OXFORDSHIRE COUNTY COUNCIL'S RESPONSE TO CONSULTATION ON THE FOLLOWING DEVELOPMENT PROPOSAL

Application no 14/02004/HYBRID:

Location: Land South Of Perdiswell Farm Shipton Road Shipton On Cherwell

ANNEX 1
OFFICER ADVICE

JOB TITLE		Woodstock East		CLIENT		Pye Homes Vanbrugh Trust	
DRAWING TITLE							
Proposed A44 site access							
SCALE	DRAWN BY	DATE	DRAWING No	REVISION			
1:1000@A3	BP	Sept14	15291-22	B

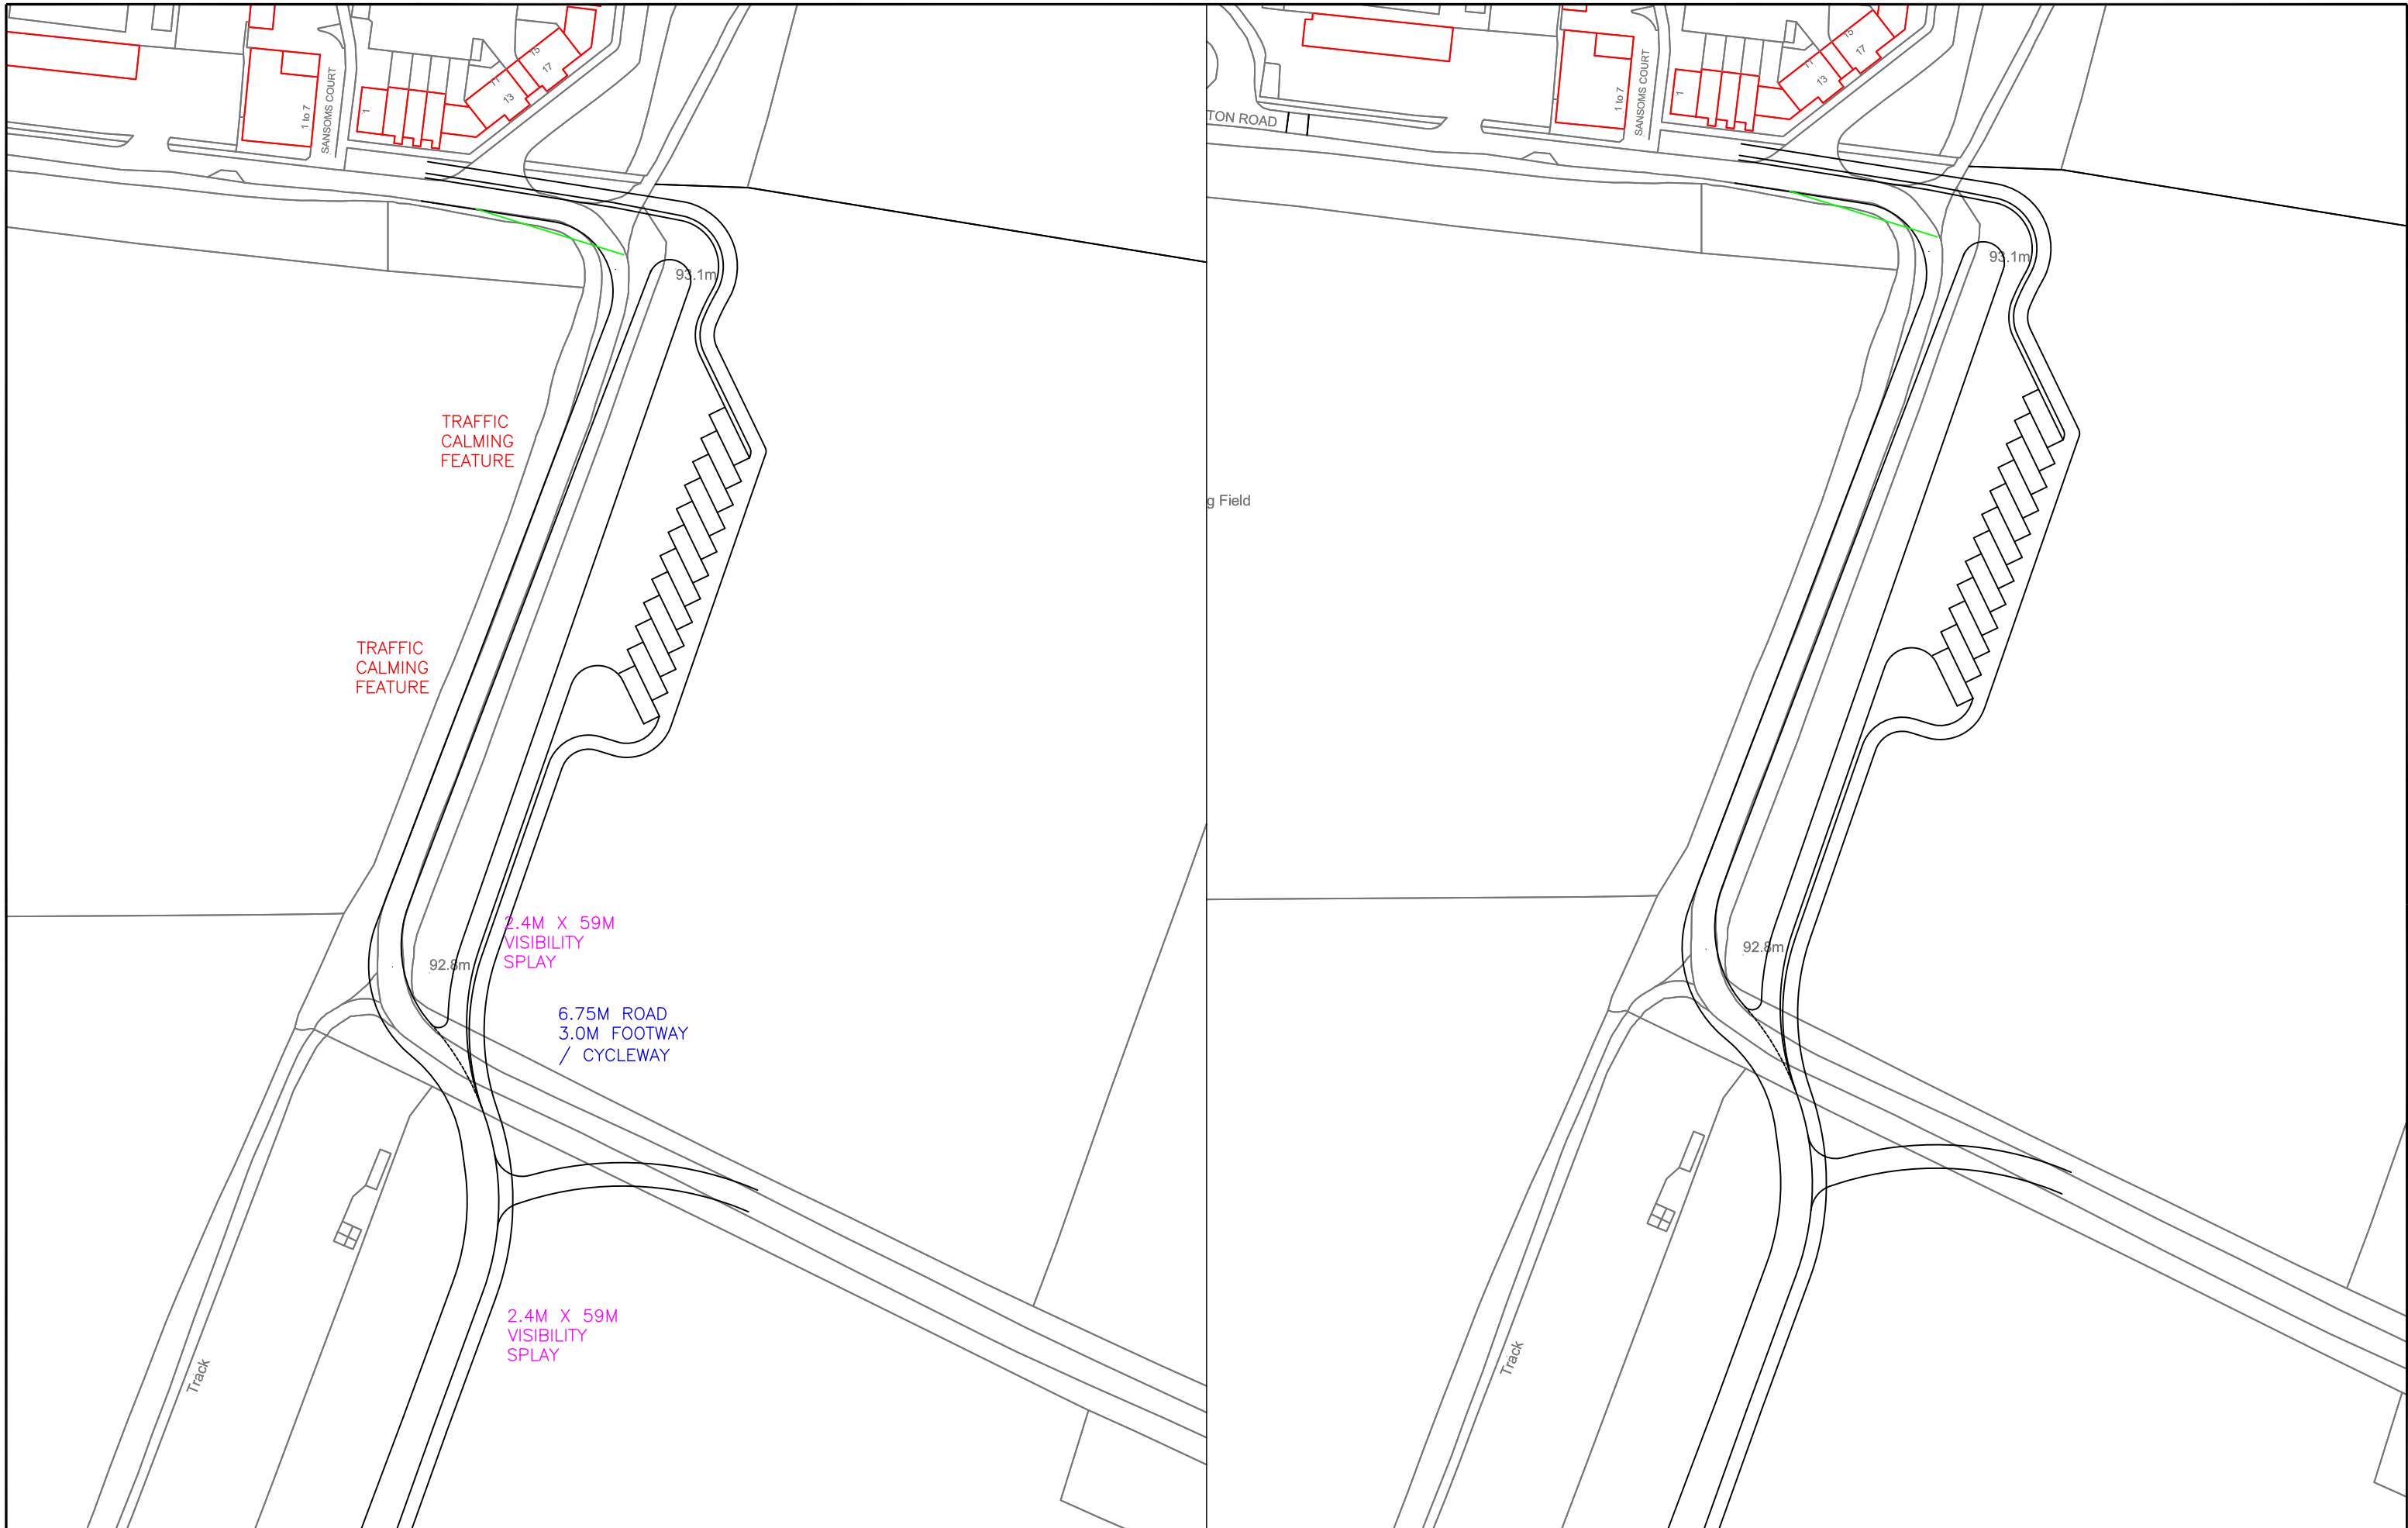
- i) the proposed priority junction to the A44 is in close proximity to an existing junction on the opposite of the road.
- ii) the layout of the proposed roundabout to A4095

- iii) the proposed priority junction to the A44 is in close proximity to an existing junction on the opposite of the road.
- iv) the layout of the proposed roundabout to A4095

Further detail is required of the site access proposal. I have concerns with regard to highway safety and convenience as the submitted plans do not appear to be in accordance with Design Manual for Roads and Bridges (DMRB). For the access to the A44 my attention is drawn to the access opposite and the lack of junction separation. For the roundabout proposed at the A4095 junction I am concerned with the poor alignment and dimension of the roundabout. The proposals should be revised to accord with DMRB and I suggest appropriate Road Safety Audits are provided with any departure from DMRB appropriately justified.
